Your Ref: OWPC7262
Our Ref: EP/120/15/HH 11-09-2015
Please ask for:
Mrs A Gardner

Remodelling & extensions
Hascombe 33 Tamarisk Way East Preston

Thank you for your internet representation made on 26th October 2015 which has been recorded as '**an objection**' with the comments as follows:

client	Jason Richardson
job	Hascombe Tamarisk Way East Preston West Sussex
dwg no.	1043.06e
title	Proposed Ground & First Floor Plans
drawn by	SM
checked by	KT
scale	1:100 @ A1
date	05.08.15

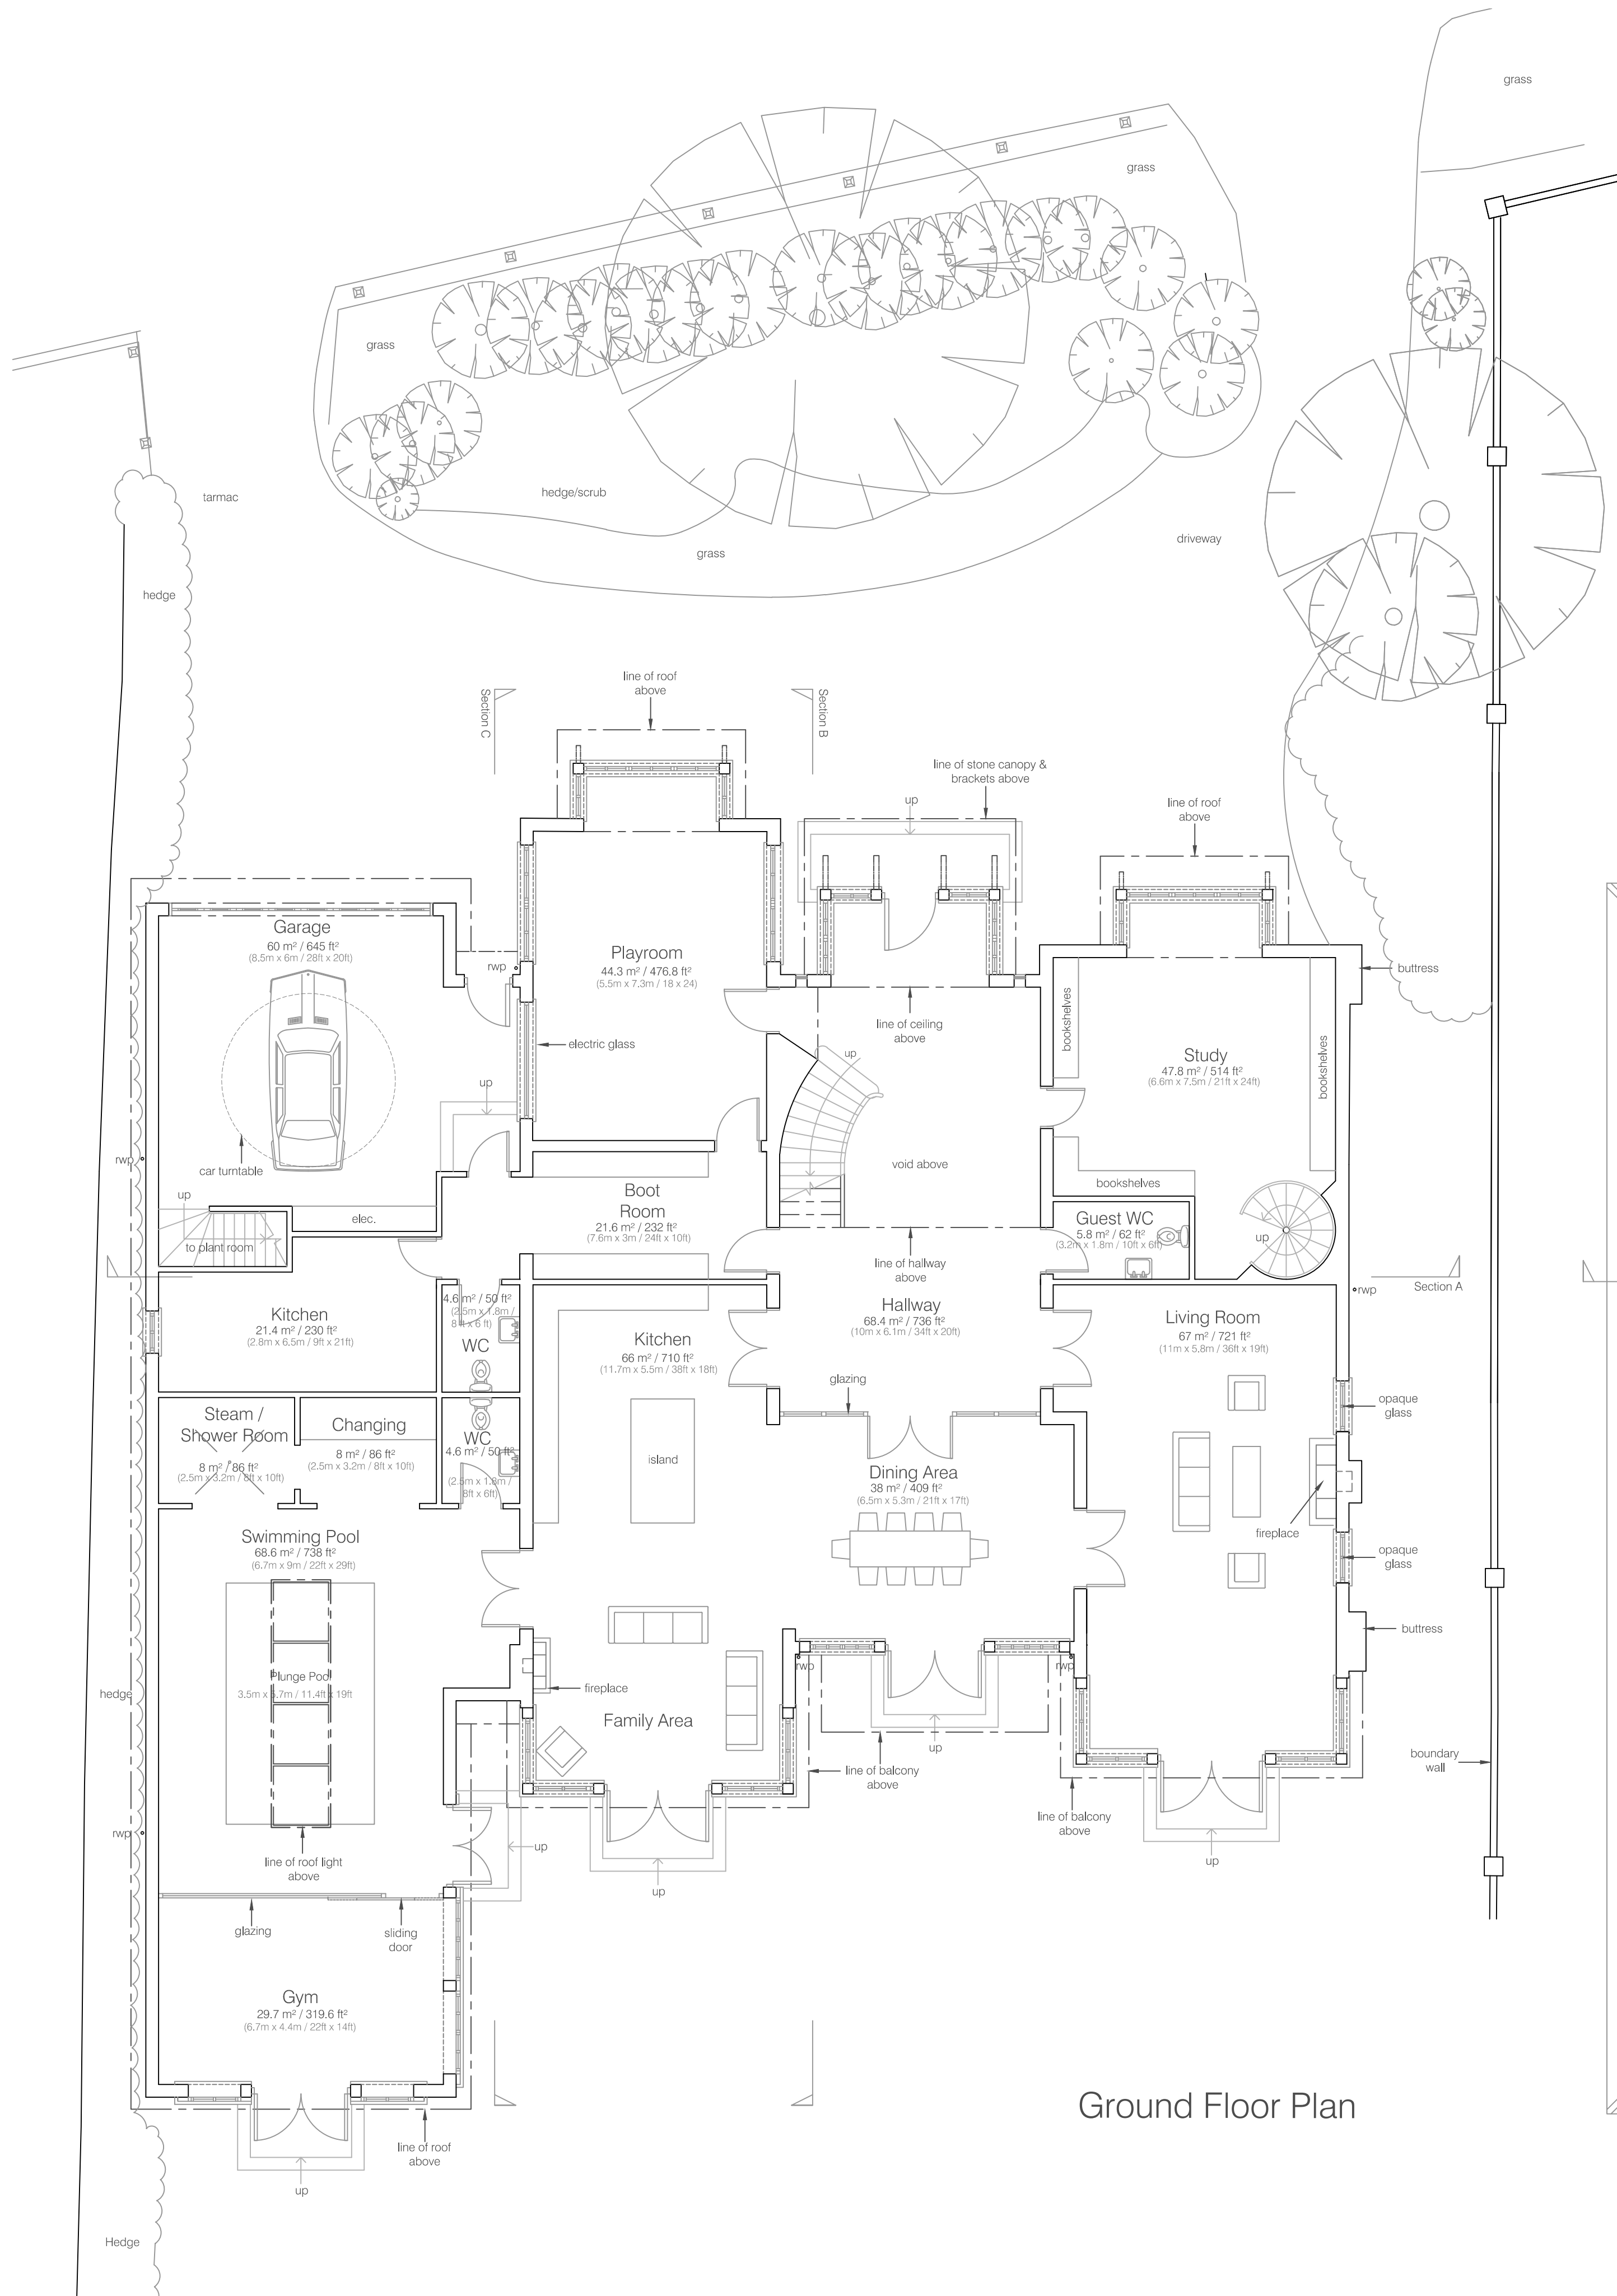
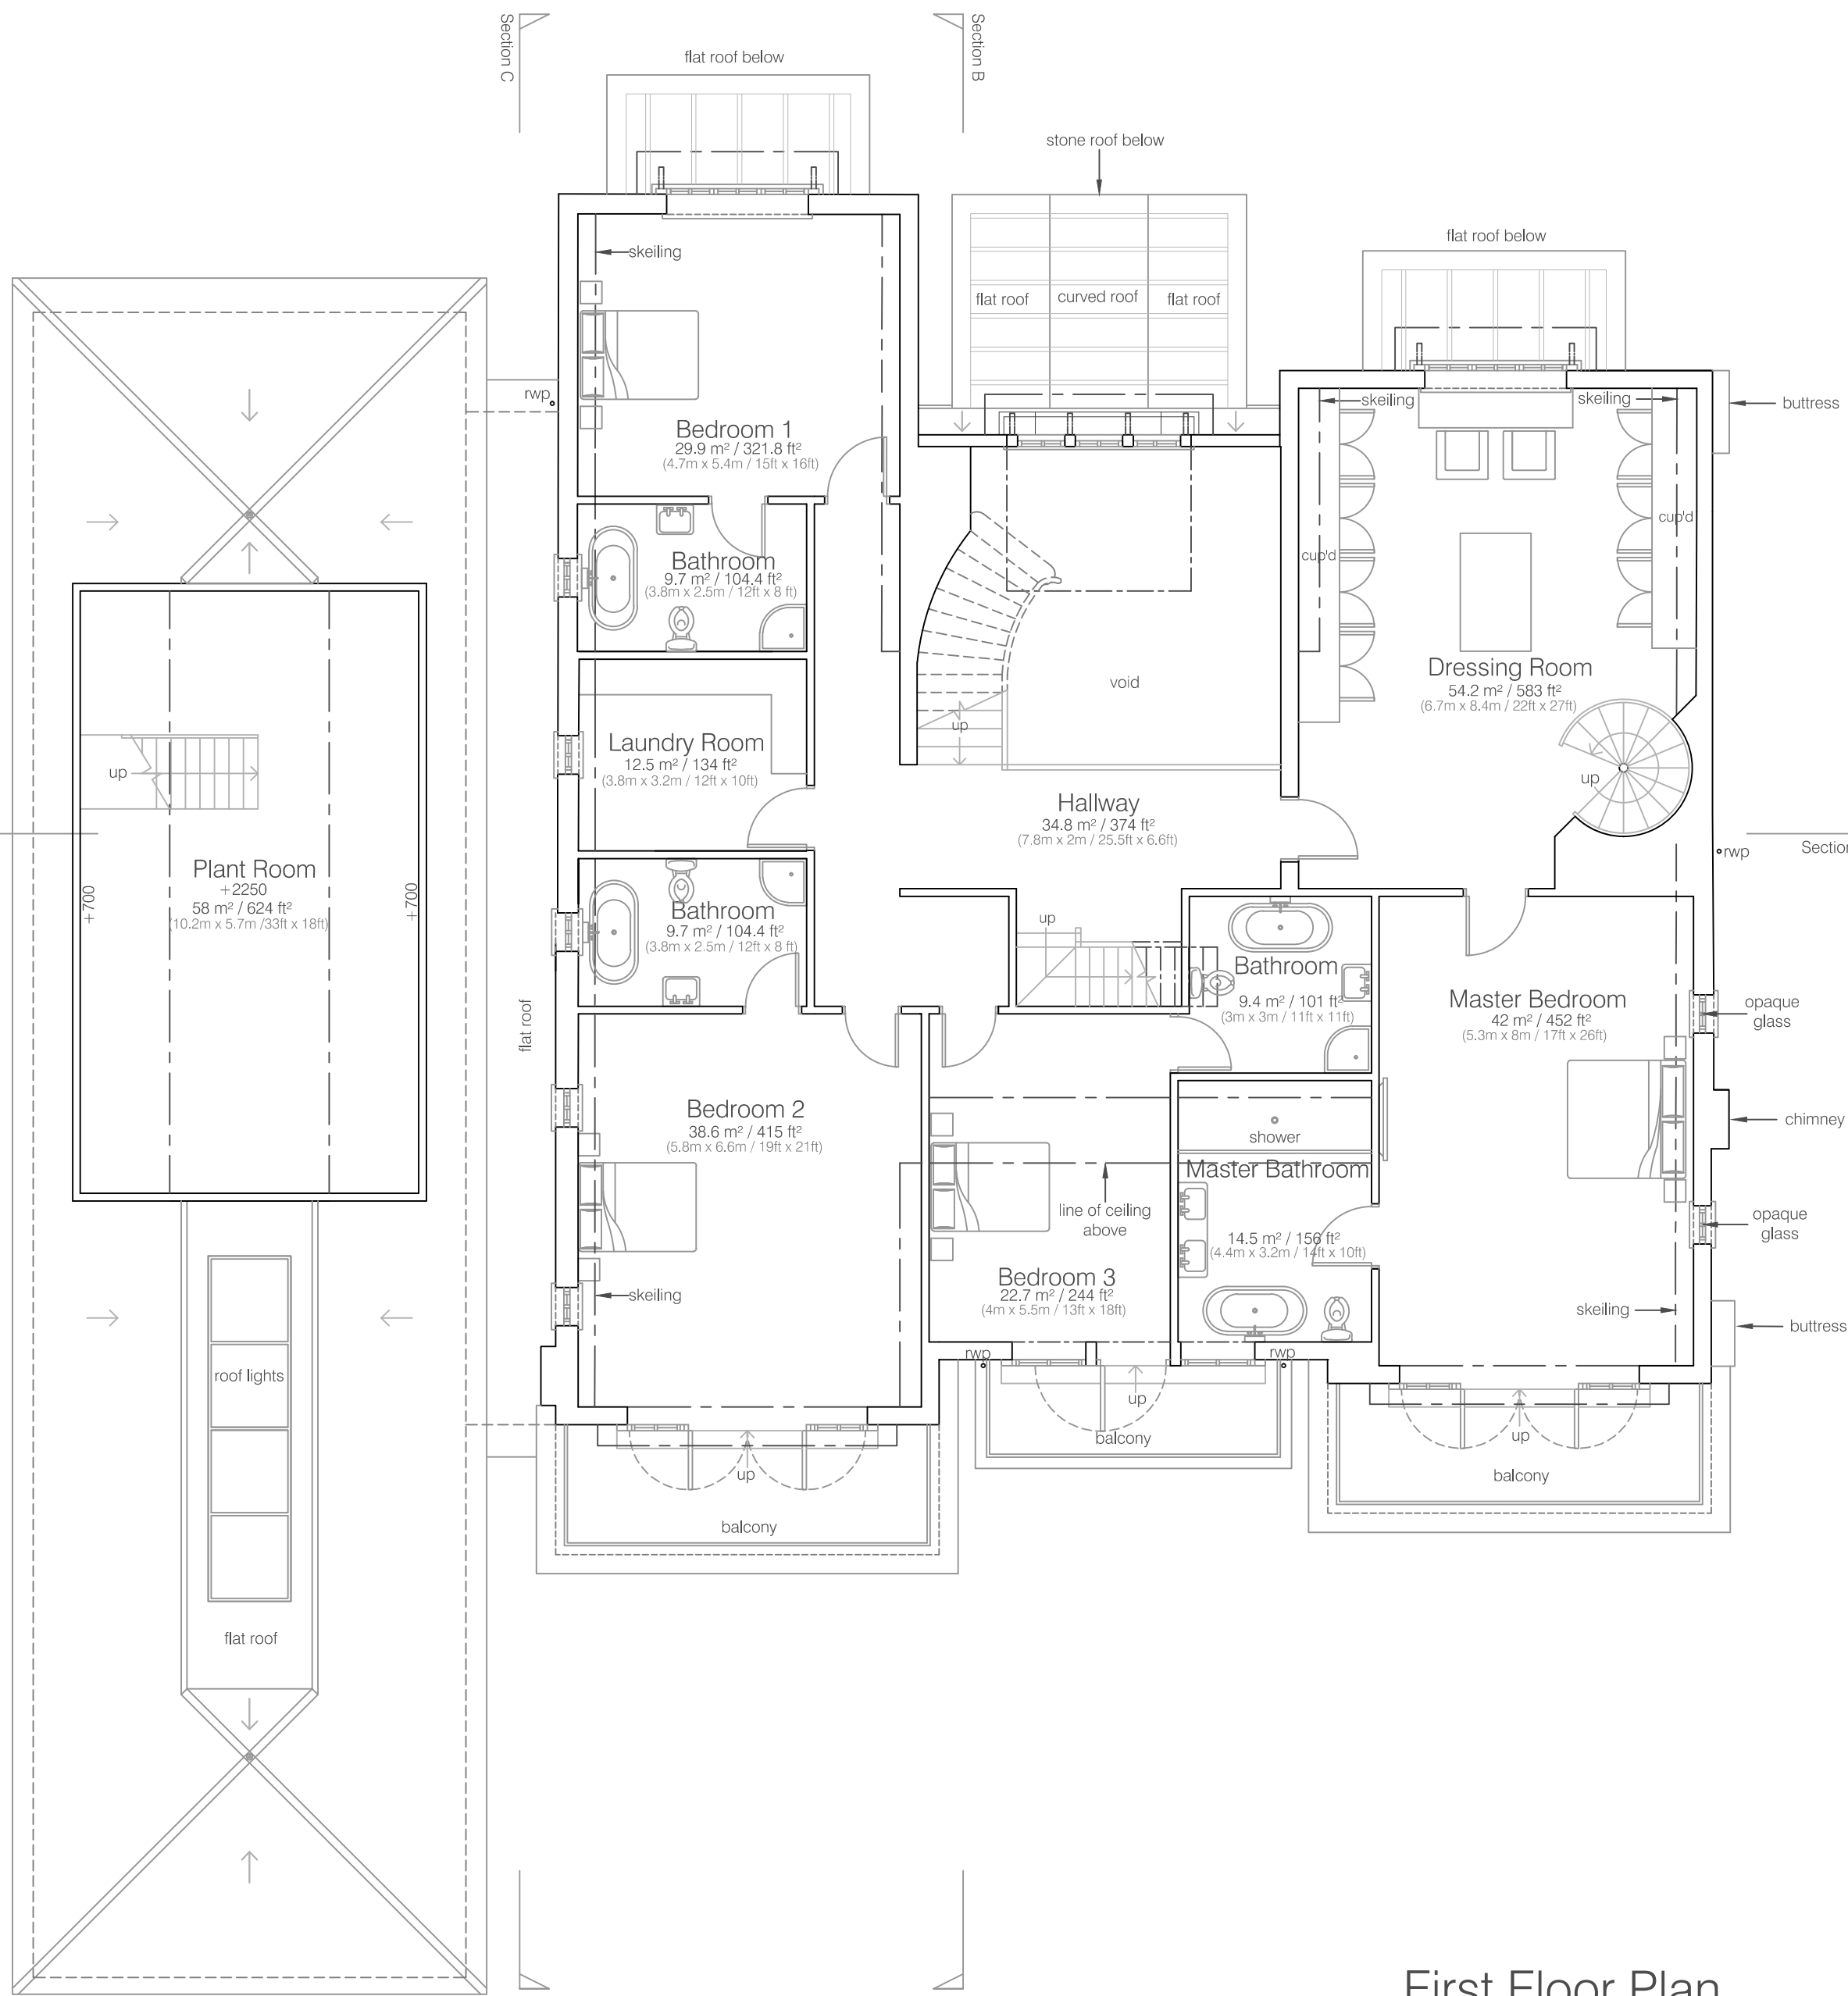
The existing / proposed elevations and layout plans provided by the applicant clearly shown the significant increase in quantum floor space on the site.

The north-east corner of the garage will be too close to the eastern boundary of the site and will result in the loss of the hedgerow presently on-site.
